Date: 18 September 2026
Our ref: 557672
Your ref: EN020026

Application by National Grid Electricity Transmission plc (“the Applicant”) for an Order granting Development Consent for the proposed Sea Link Interconnector project (“the Proposed Development”)

The following constitutes Natural England’s formal statutory response to the Secretary of State’s Request for Information (RFI) dated 18th of September 2026. To inform this response Natural England have reviewed the following documents:

Appendix B Distribution of dormouse survey tubes in Kent

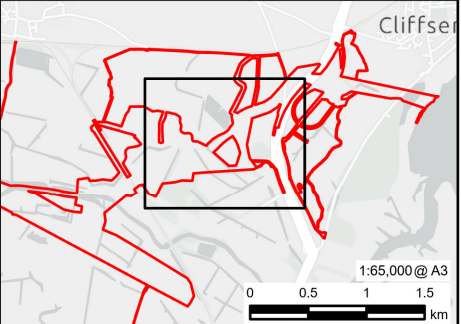
The score provided for Zone D of the survey area is 14.96, below the threshold at which likely absence can be concluded. Therefore, these surveys cannot reliably be used to support a conclusion of likely absence.

The score for Zone B does exceed the 20 threshold; however, it is not clear from the figures how well connected the habitat between the subsections of Zone B is. The Handbook (second edition) recommends that at least 50 tubes are used per survey and highlights the risk of missing dormouse presence when small numbers of tubes are used. Surveys in Zone B3 used only 5 nest tubes, and B4 used 10. Without further detail from the applicant on the connectivity between these subsections, and the justification for the numbers of nest tubes used, it is difficult to determine the acceptability of Zone B survey methodology.
